Case Officer: Gemma Magnuson **Recommendation:** Approve

Proposal: Variation of Condition 2 (plans) of 19/01763/LB

- 1.1. The Old Post Office is a detached Grade II listed building situated north-east of the village of Sibford Ferris, in the Conservation Area. Other Grade II listed buildings are situated in close proximity to the site to the east. A Public Right of Way runs adjacent to the site to the west. The site is of archaeological interest and is likely to contain naturally elevated levels of Arsenic.
- 1.2. The building became a listed building in September 1988 and is described as an early/mid 18th Century house. It is understood that it is the former post office serving the village and a post box remains in the front elevation.

Scale:
 1:100 @ A3
 Number:
 200_Rev.D

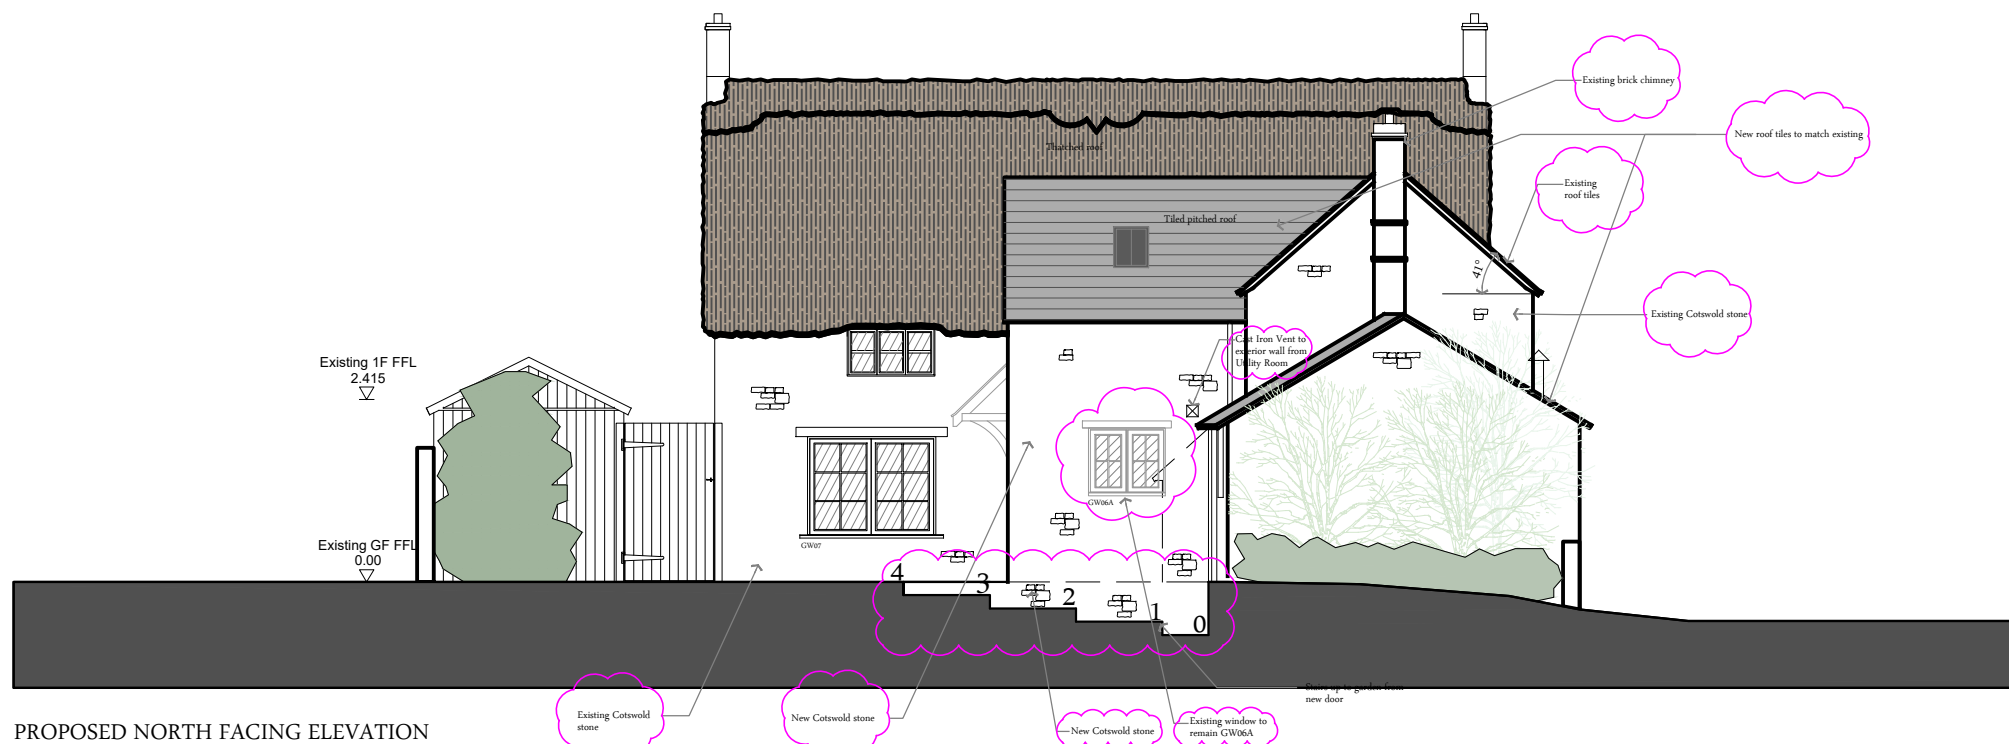
- 2.2. Amendments made under the 2019 application related to the openings. The current application seeks the following additional amendments:
 - Retention of an existing ground floor window on the north elevation

- Installation of vents
 - New roof tiles to match those existing on single storey former ancillary building
- 2.3. Application 20/01196/F accompanies this application for planning permission.

- 6.3. CDC Conservation - There are no particular objections to the minor alterations to the plans. A stone sample panel will be required for the wall and further details of the proposed vent will need to be provided. These can be dealt with by condition if necessary.

- 8.8. Further details of the vents are required although these can be sought via condition, as suggested by the Conservation Officer.
- 8.9. I consider that the historic significance of the Conservation Area, the listed building, its setting and the setting of nearby listed buildings would be unharmed by the proposed amendments, in accordance with the above Policies

1. Except where otherwise stipulated by conditions attached to this permission, the development shall be carried out strictly in accordance with the information contained within the application form and the following approved plans: Site Location Plan, Drawing No's: 100_Rev.D, 110_Rev.D, 200_Rev.D, 210_Rev.D, P-19-W-01 Rev. C, P-19-W-02 Rev. F

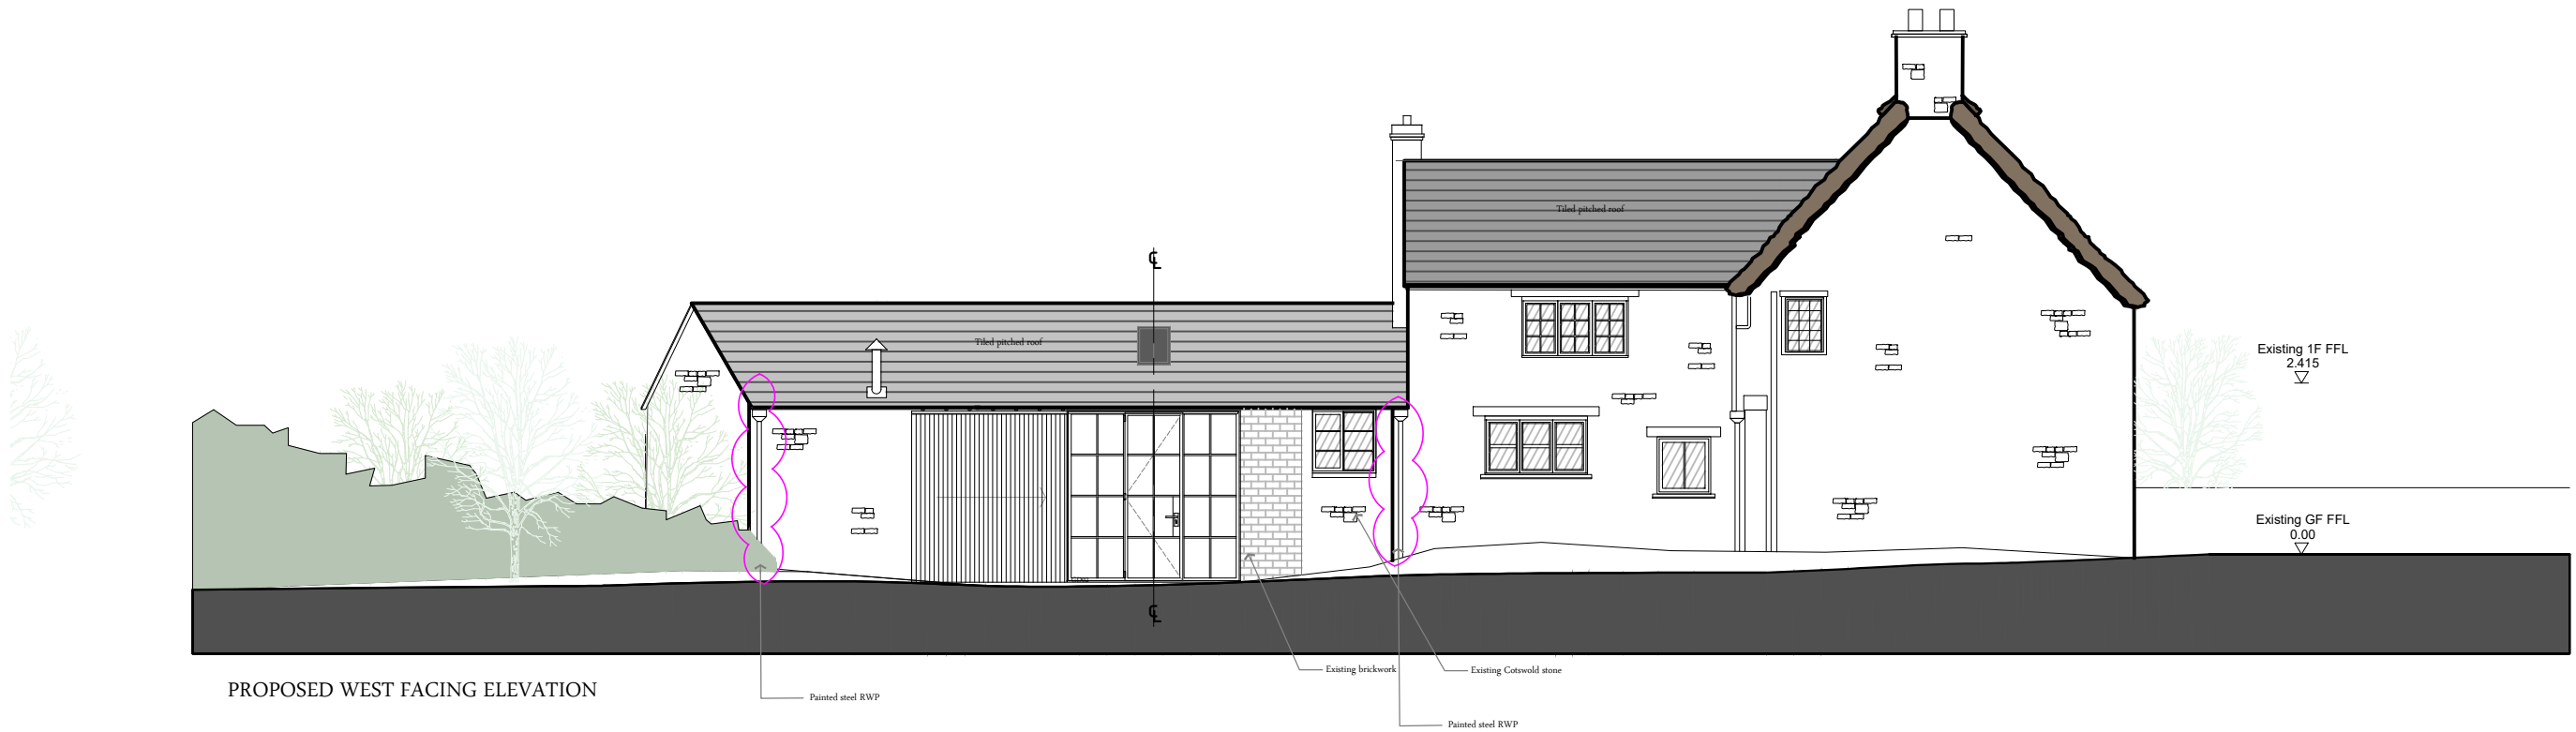
- Creation of steps within the garden down to a new Crittall door in the east elevation
 - Rebuilding of existing extension using Cotswold stone (there had been an inaccuracy on the previous decisions where ironstone was used instead of, I believe, Cotswold stone.
